**CITY OF ALBUQUERQUE
PLANNING DEPARTMENT
August 31, 2011
DRB Comments**

PROJECT # 1002629

RE: Lots 10 & 11, Davidson Addition No.1

TITLE: **SITE/ UTILITY PLAN**

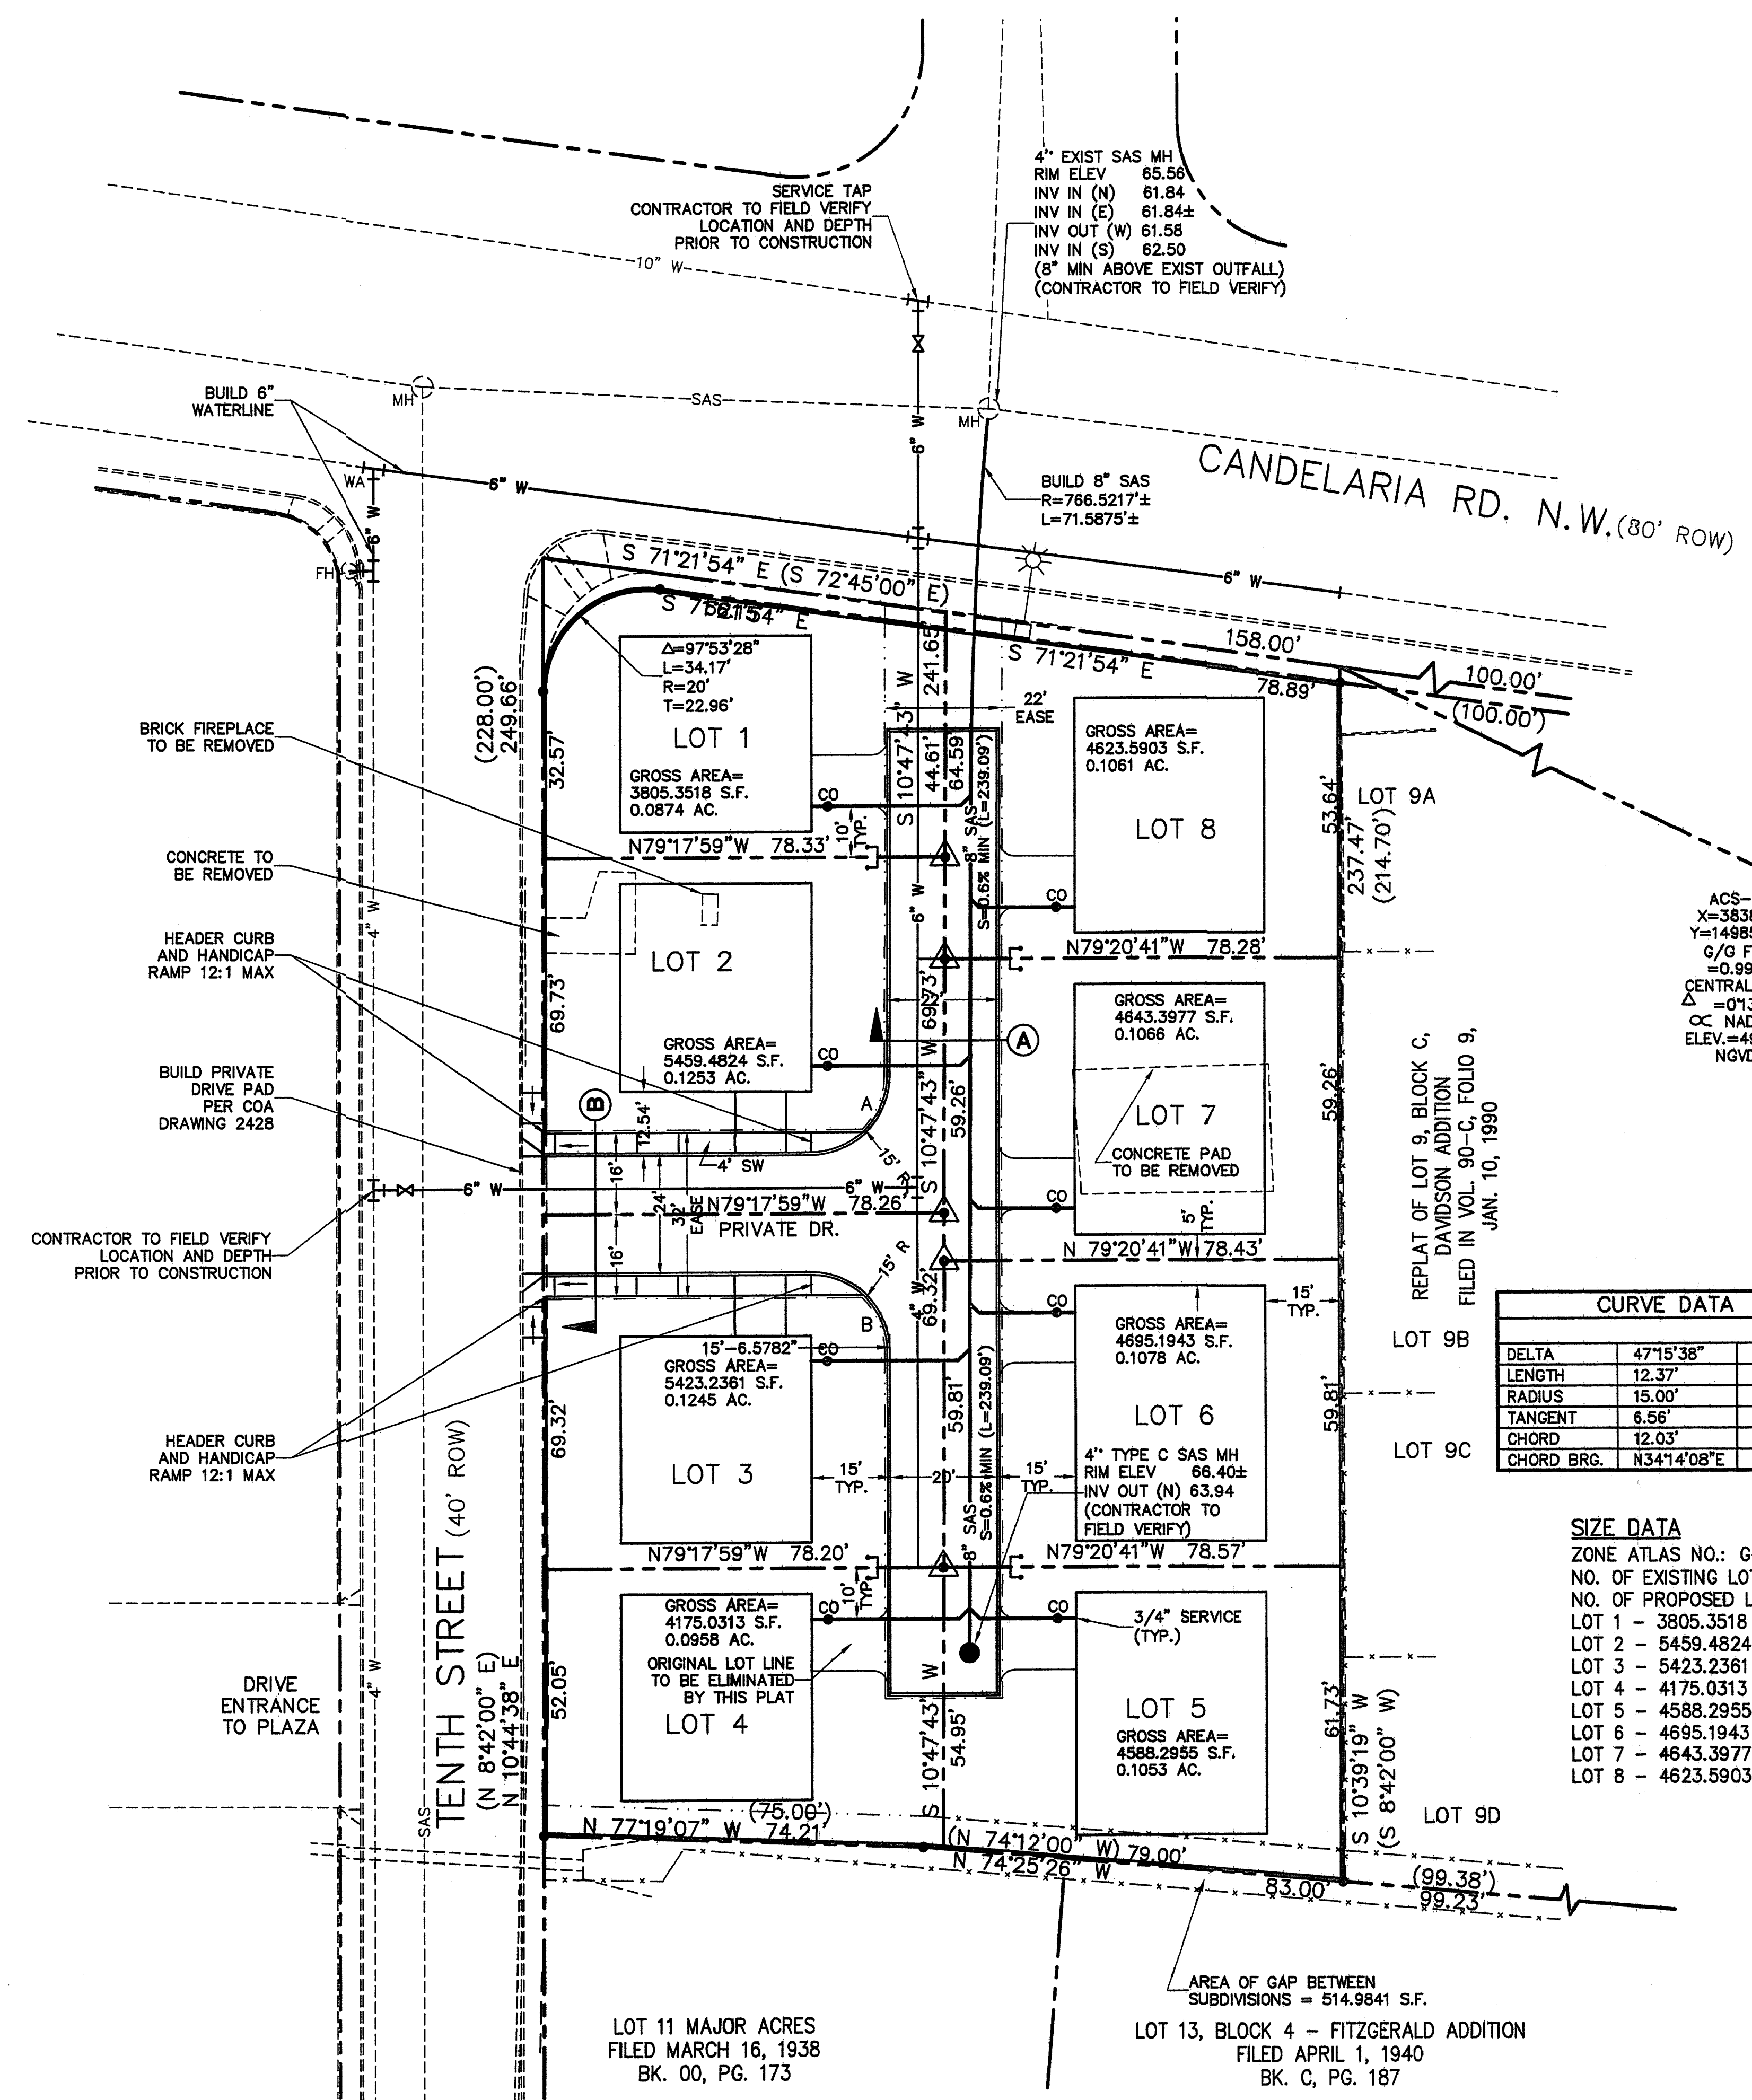
1. Public easement for water and sewer must be **EXCLUSIVE**. The dry utility easement (P.U.E.) may NOT share the public water and sewer easement.
2. How does the sewer work? Sewer services are typically minimum 4 feet bury at the curb line, but your manhole is only 2.5 feet deep.
3. Comments on the infrastructure list.

**SUBDIVISION OF
DON JUAN DE ONATE
ALBUQUERQUE REDEVELOPMENT DEVELOPMENT
OWNED AND BUILT BY BRENDAN T. O'SULLIVAN
WITHIN SECTION 5, T.10 N., R. 3 E., N.M.P.M.
CITY OF ALBUQUERQUE
BERNALILLO COUNTY, NEW MEXICO
MARCH 2005**

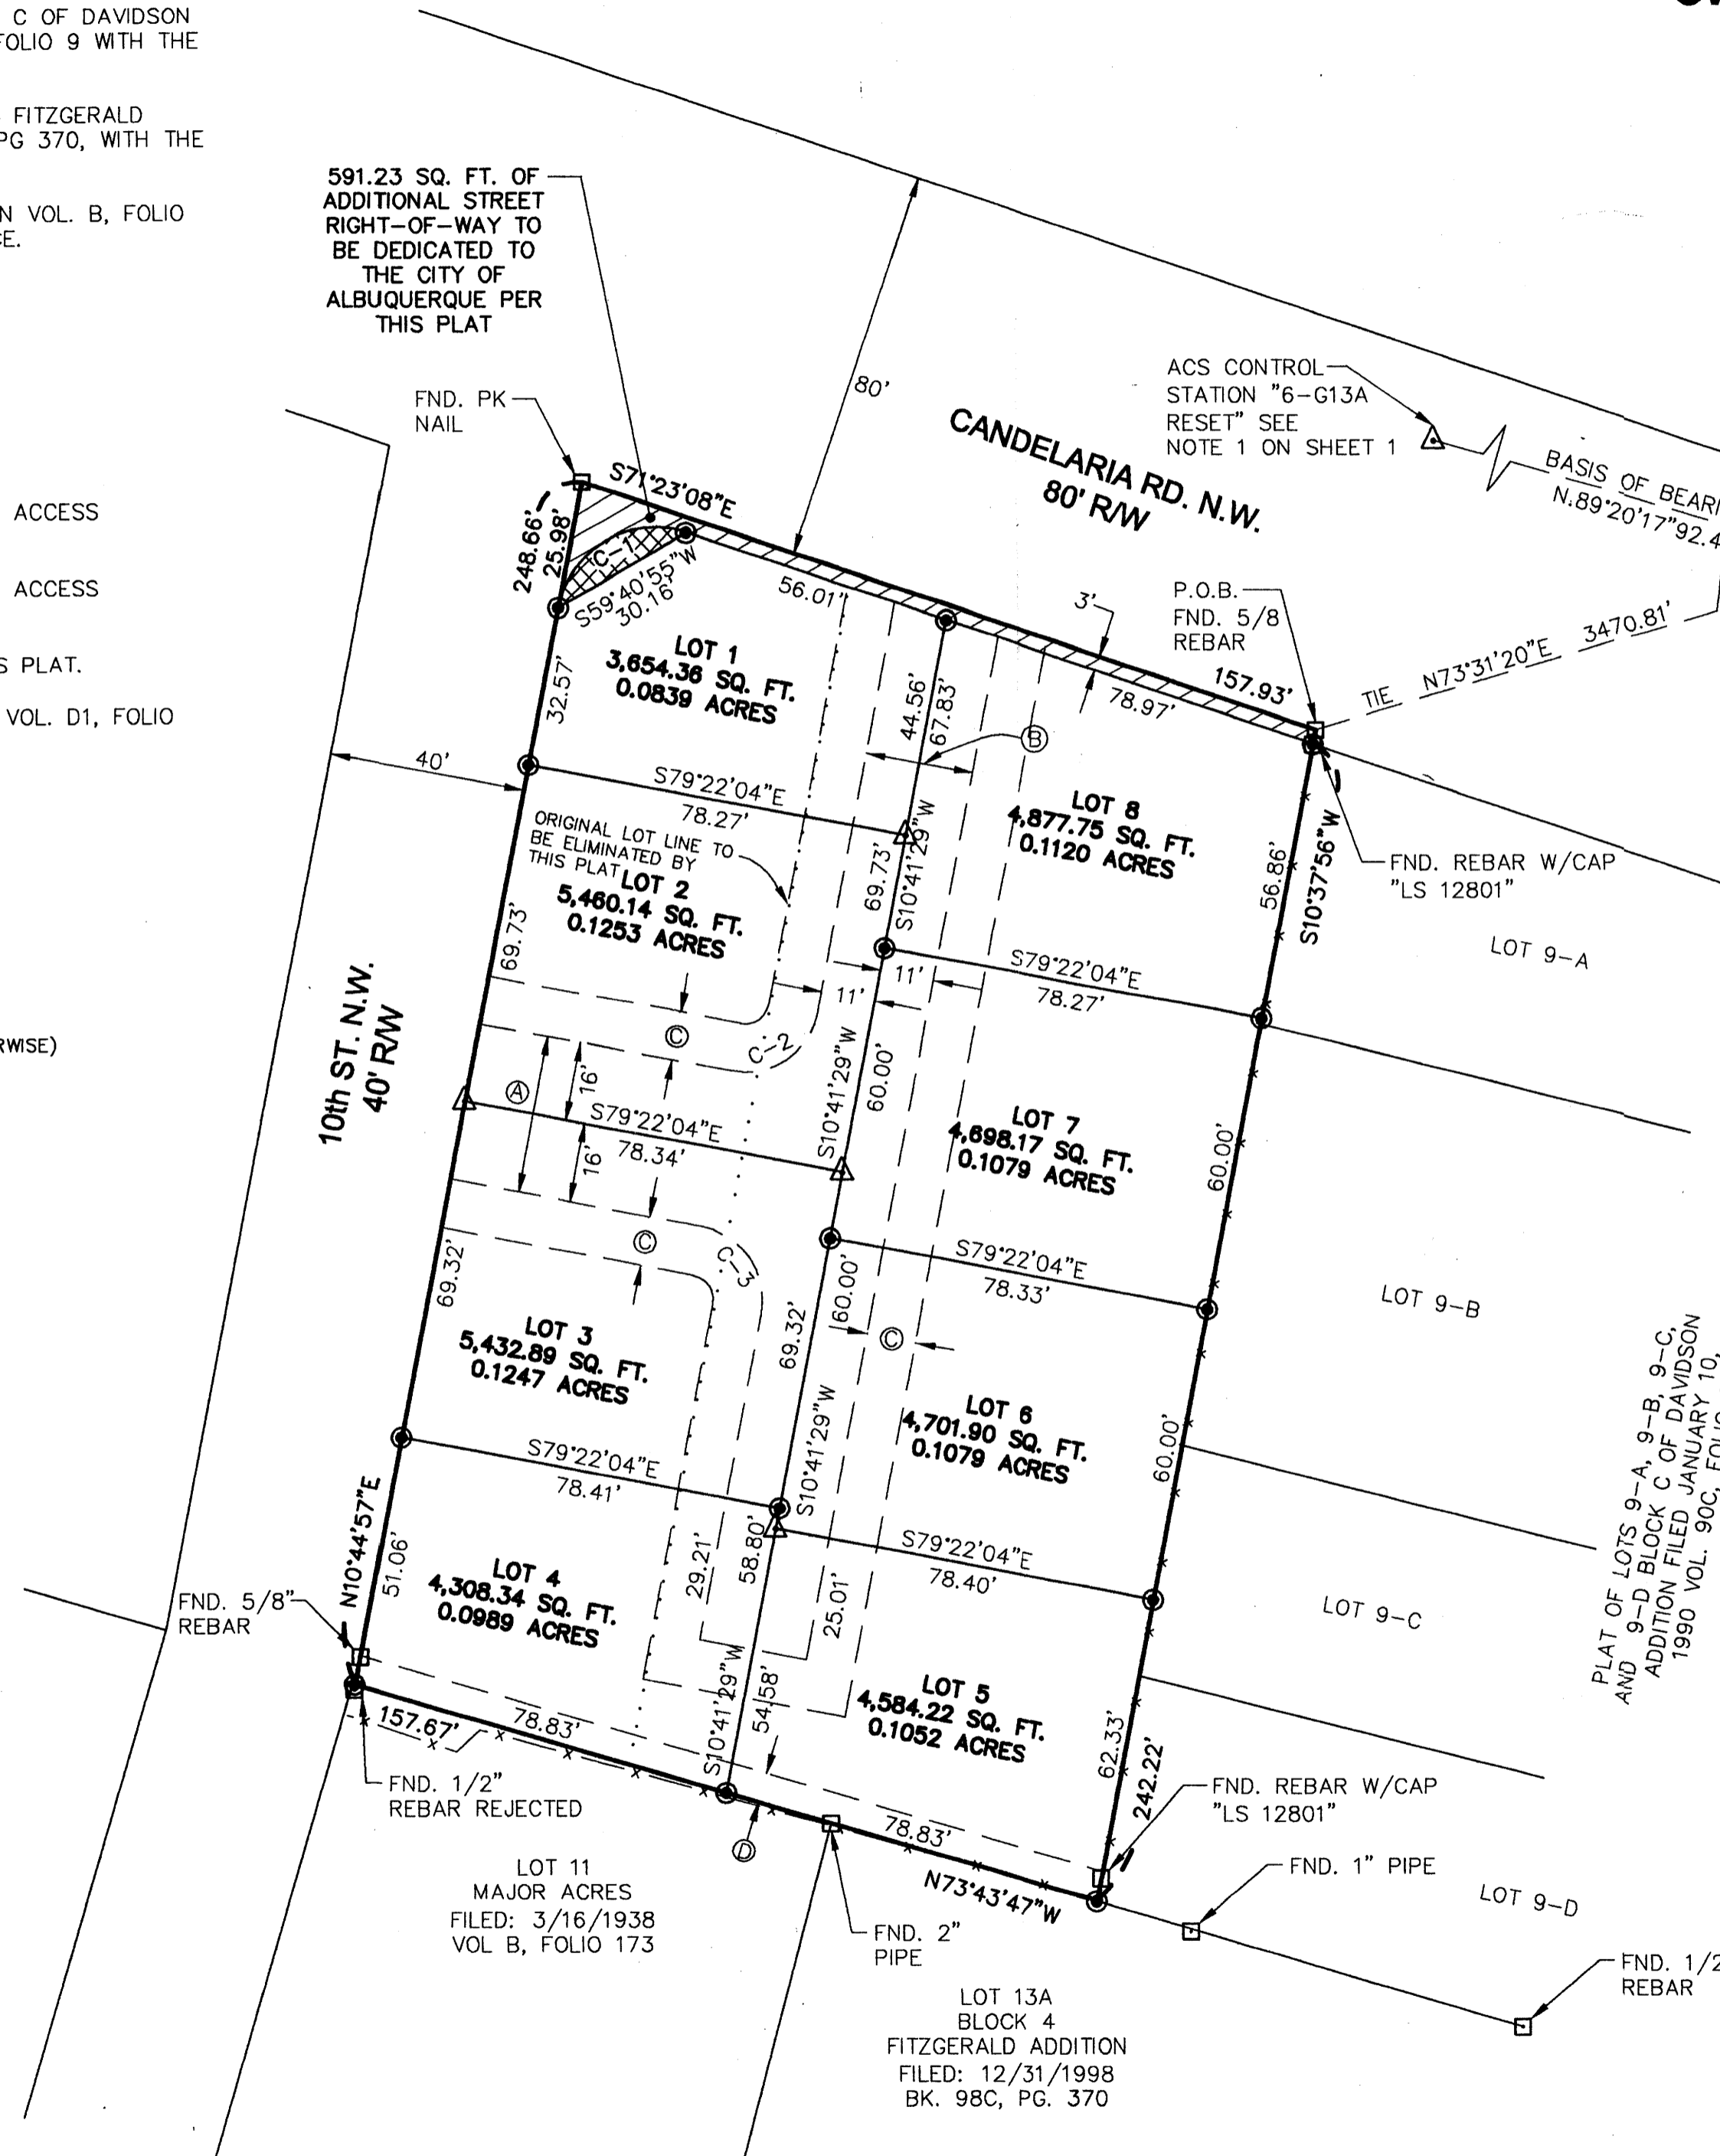
✓ The current zoning should be listed on the plat under Subdivision / Data.

✓ The signature of Brendan T. O'Sullivan appears under Don Juan de Onate, Albuquerque Redevelopment Development. If he is an owner as the plat title indicates, this status must be indicated under the line where his signature appears.
